Sustainable Traffic Solutions

September 13, 2024

RE: Responses to Comments on the Traffic Impact Study for the Haven School

CONCEPTUAL IMPROVEMENT SKETCH FOR MILAM ROAD AT BURGESS ROAD

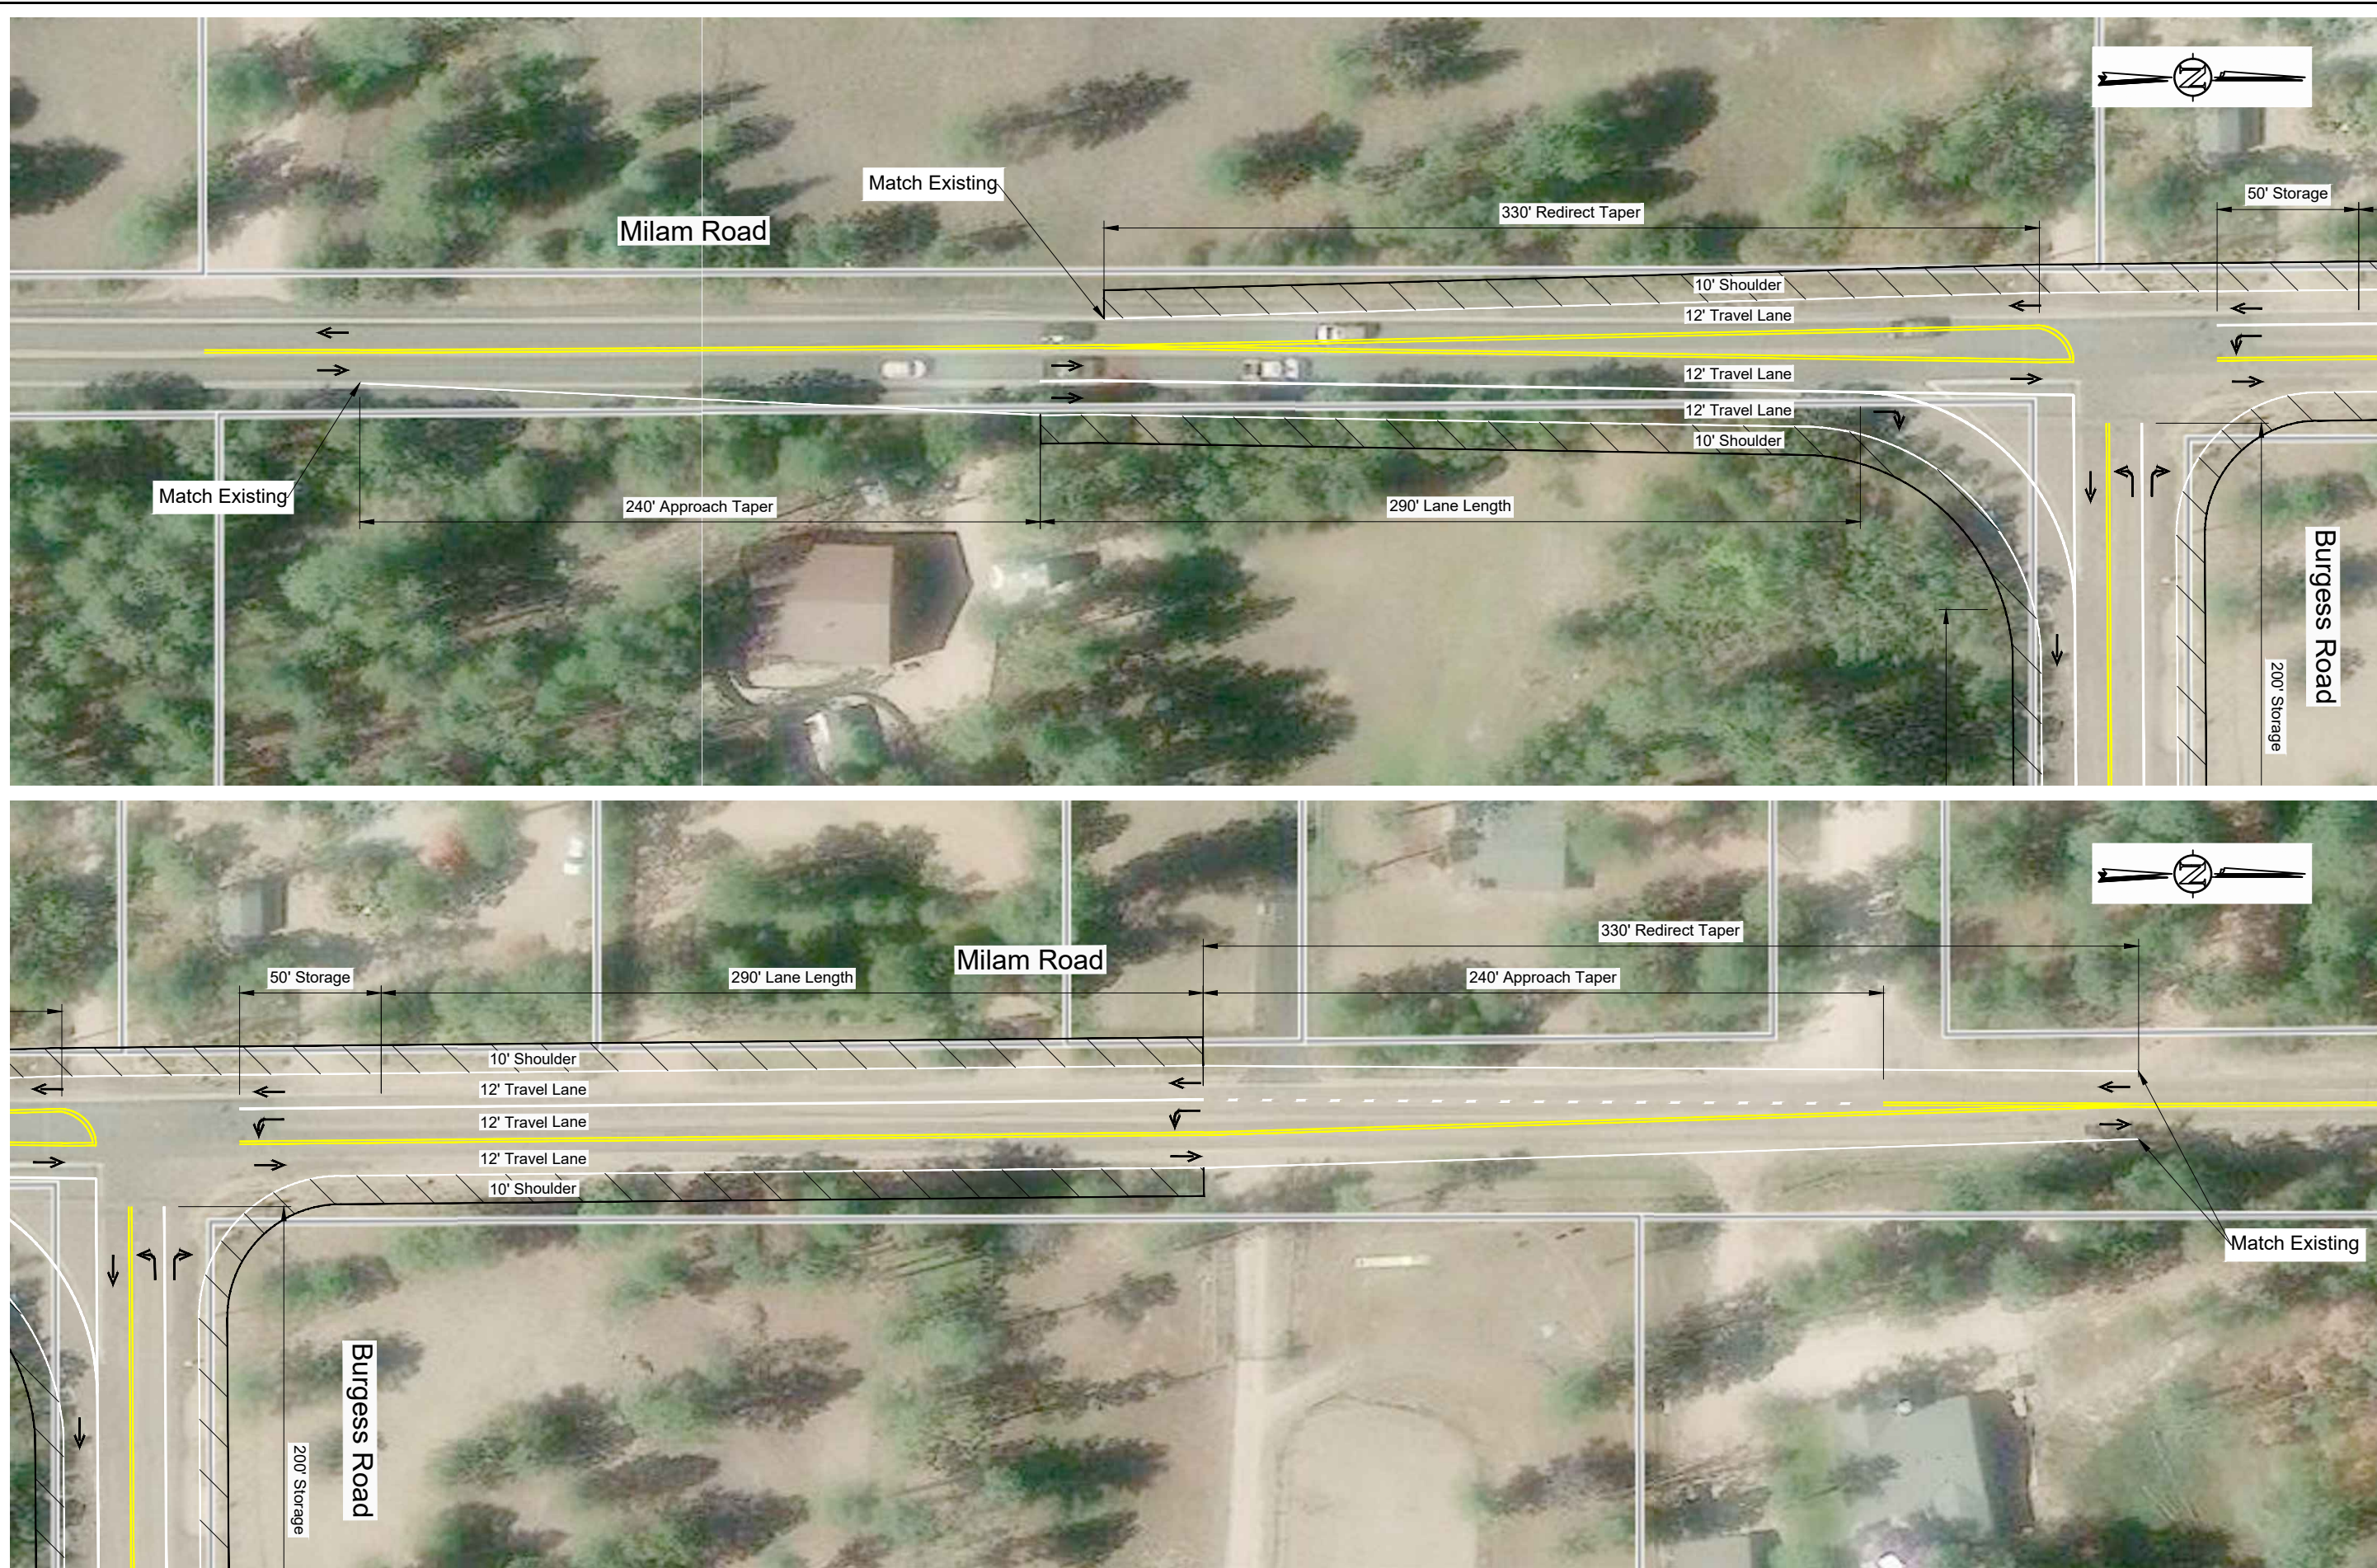
Comment 1 Add and compare LOS analysis if lane improvements are not added at Milam and Burgess. (Refers to the Year 2026 traffic conditions.)

Comment 2 Discuss if the current peak hour has tripped the needed lane improvements at Milam and Burgess without the school added. Discuss that the Milham and Burgess intersection can operate safely with the school open and the off-site improvements not completed (not including access improvements on Burgess). (Refers to the auxiliary lane review.)

Response Refer to Section 5.0.

Response Refer to Section 9.0 and Table 4.

Figure 22 – Intersection Sight Distance at the Site Access on Burgess Road

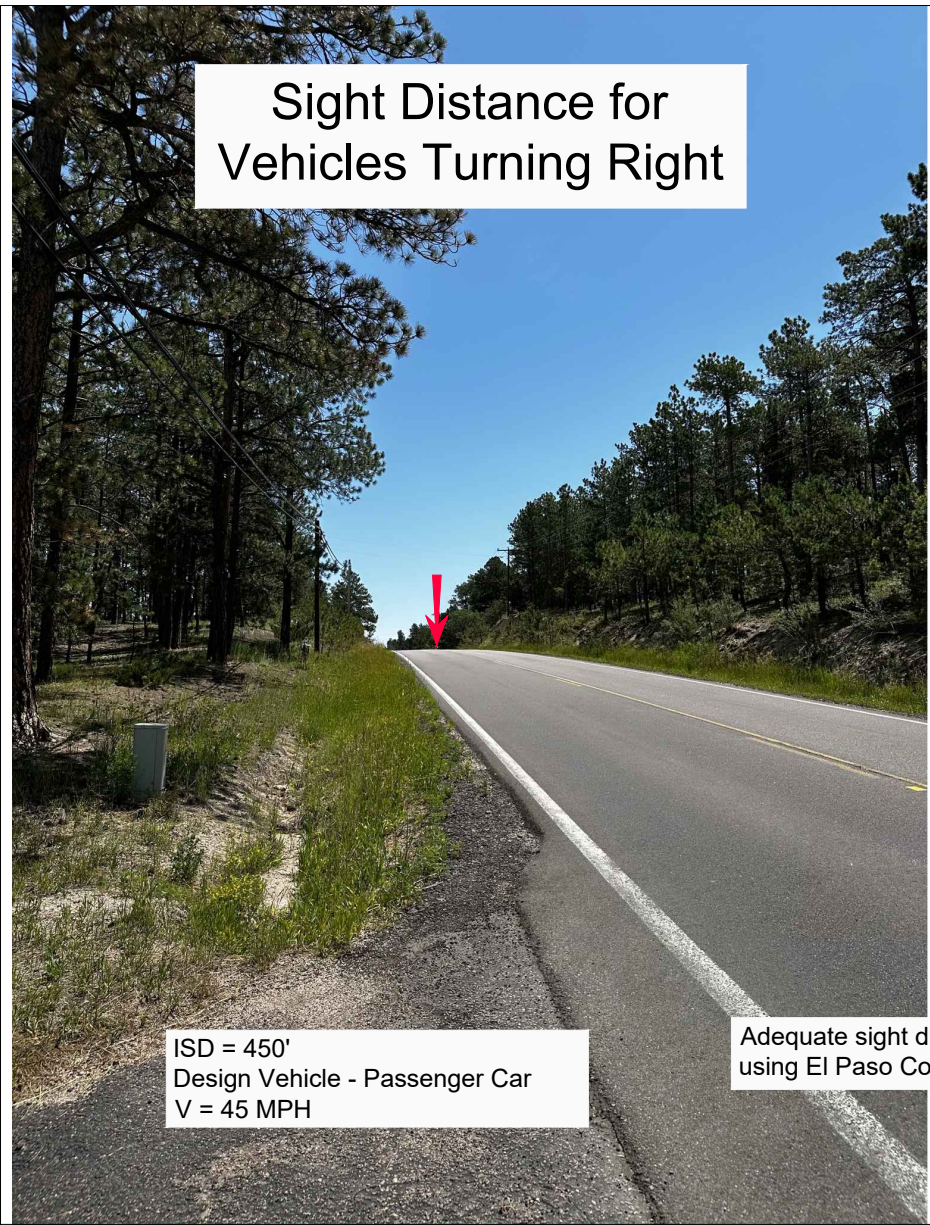
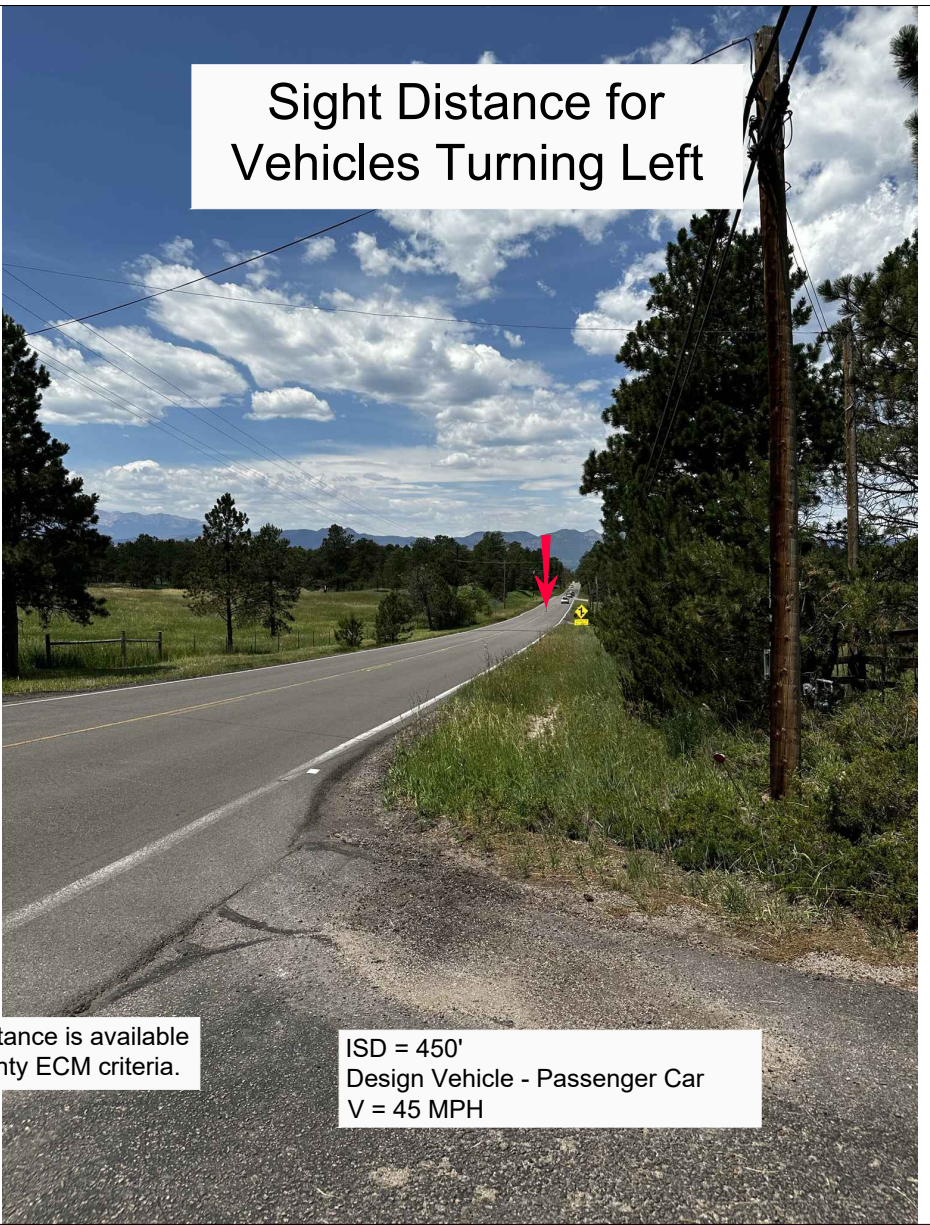
Comment 4 note this will be a condition of approval to restrict bus service due to line of sight not able to be met (Refers to Section 10.0.)

Response The school understands this.
